From: Louise Blatchford
Sent: 16 May 2012 16:50
To: 'hughestreacher@aol.com'
Cc: Lesley Lund
Subject: Planning application - The Barn, Preston Road, Alston
Attachments: Scoring.pdf; LIST OF ECOLOGICAL CONSULTANTS WHO UNDERTAKE SURVEYS FOR PROTECTED SPECIES INCLUDING BATS.doc; Letter - bat surveys.pdf

RE: Change of use from workshop/office to residential
 AT: The Barn, Preston Road, Alston

**Proposed Conversion of Existing Rural Workshop
to 2 no Dwellings, Roadside Farm
Alston, Preston PR3 3BL**

Dwg no 1136/15

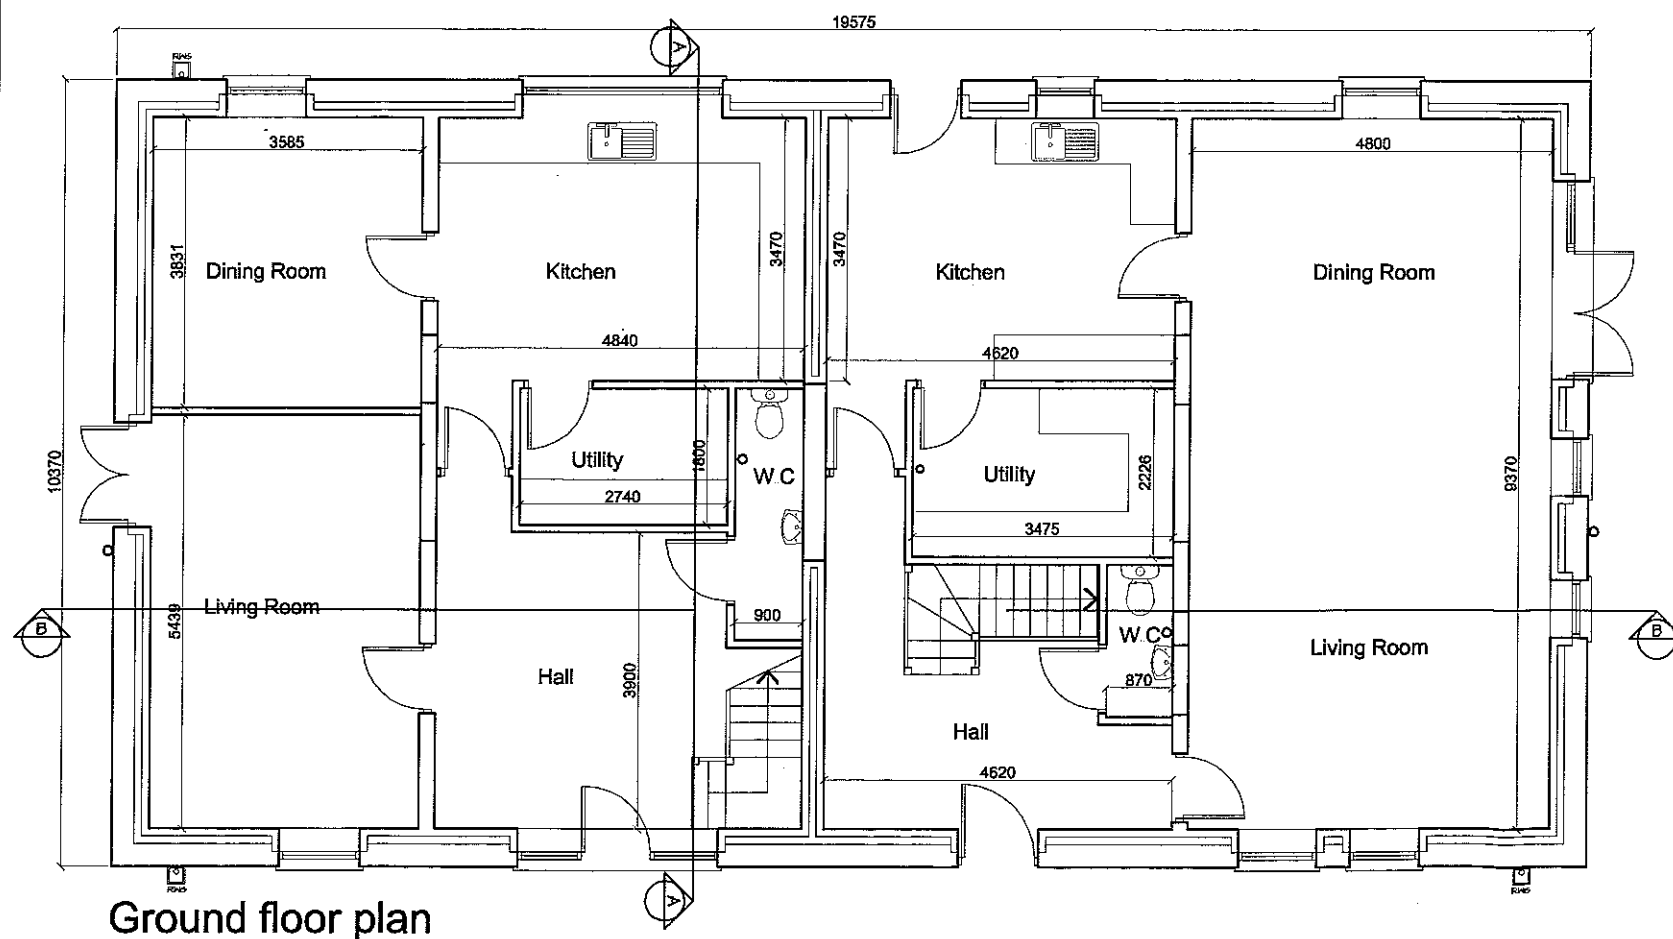
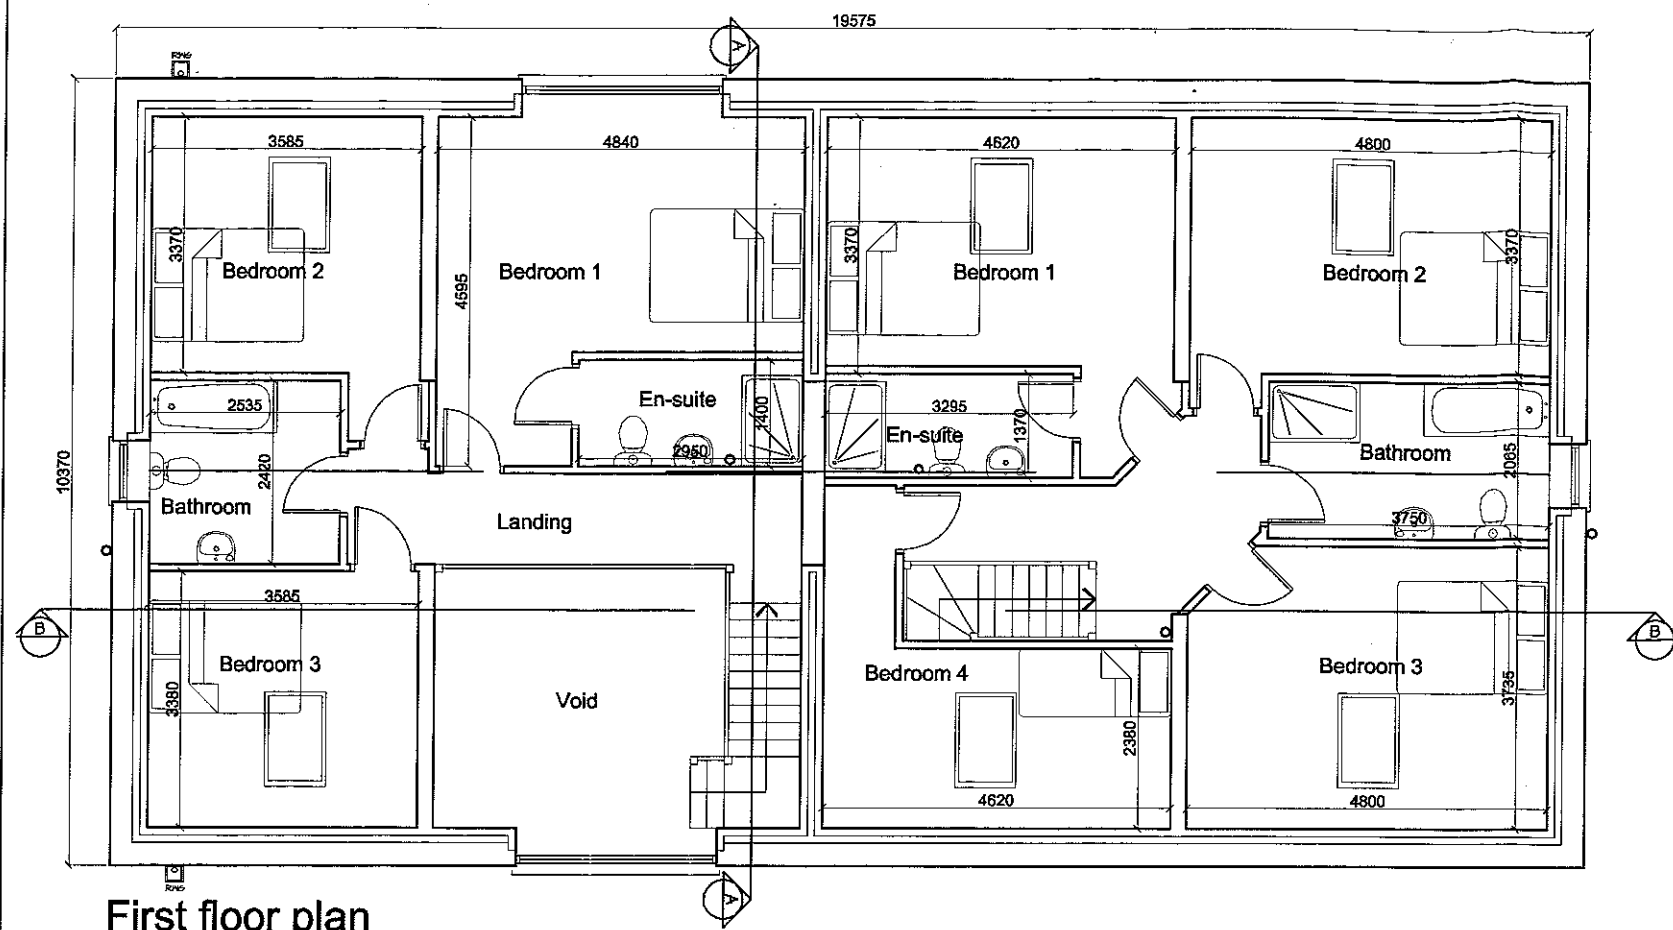
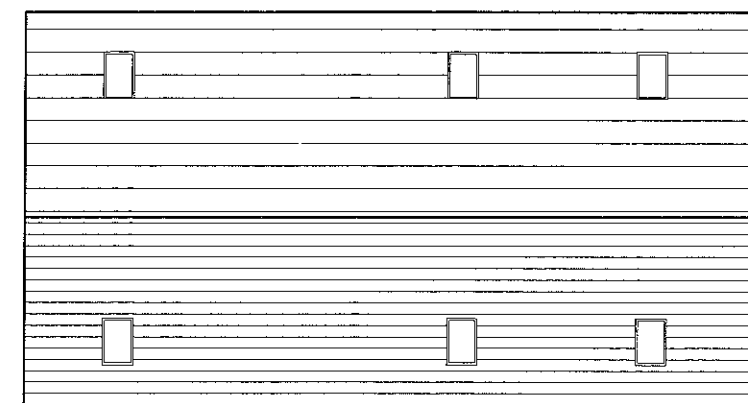
(On drawing no.1136/15 the length dimensions are partially missing - I've checked on the drawing on the Planning Portal and they're the same on there. Is it possible to show the dimensions in full and e-mail me the drawing or you can re-submit it via the Planning Portal. Please can you let me know if you're going to do it via the Planning Portal. Many thanks.)
